The Coal
Authority

Re: Application 2025/44/91637/E

Discharge of details reserved by conditions 3 (coal investigation), 5 (site investigations: phase 2), 6 (site investigations: remediation), 7 (site investigations: remediation implementation and unexpected contamination) on previous permission 2024/91760 for erection of 19 dwelling houses with associated car parking, landscaping and boundary treatment and other associated associated works; Land adjacent to Healey Junior Infants and Nursery School, Healey Lane, Healey, Batley, WF17 8BN.

Drawing Title:
 Investigation Works Record Sheet

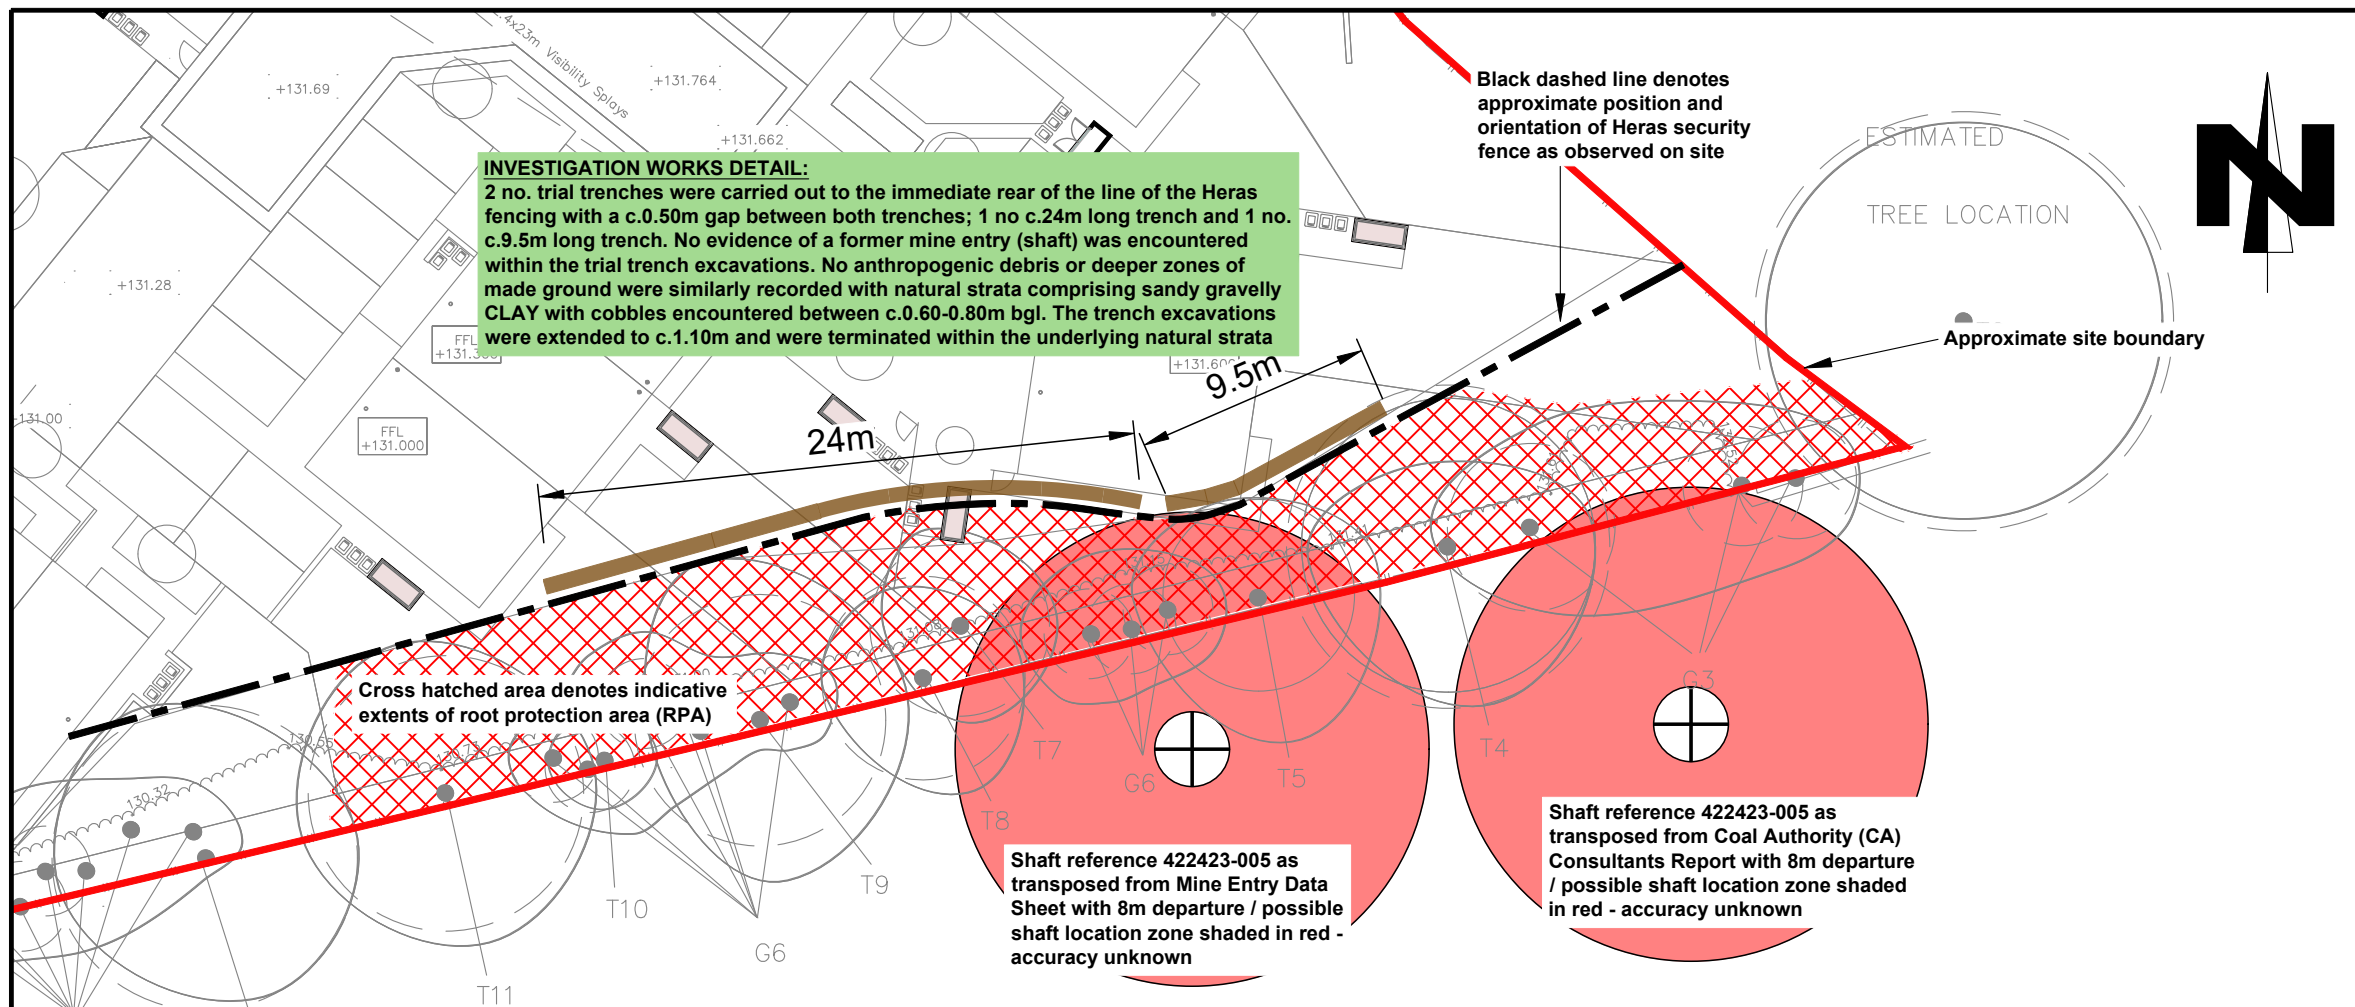
We note that because of tree protection orders affecting the southern border of the site investigations by trenching to locate the recorded mine entry were inhibited by an inability to investigate the protected tree root protection zone occupying ground closest to the plotted position of mine entry 422423-005. That position was revised following examination of source abandonment plans to its current position of 422740E, 423954W the westernmost position shown on the 'Investigation Works Record Sheet' within the Arc letter report which includes consideration of the assigned (8m) positional error of the entry.

'no evidence of this feature was recorded onsite' However because of the restrictions on investigation extent they advise foundation precautions;

'As a mitigation measure, the foundations to the property closest to the potential mine entry (Plots 8 & 9) will be extended and based wholly within the natural bedrock at a depth of c.1.80m bgl.'

On the basis of the conclusions and recommendations made by a competent person providing their professional judgement in the matter of ground instability the Coal Authority's Planning Team consider the applicant has demonstrated compliance with Condition 3a.

Since foundation precautions are recommended and yet to be implemented but may conflict with the pre-commencement nature of the condition wording, we would have **no objection to the LPA discharging Condition 3, should it see fit. However, it should be noted that we would expect the statement/declaration required by Condition 4 of the approved consent to confirm the implementation of the foundation precautions recommended in the letter report.**
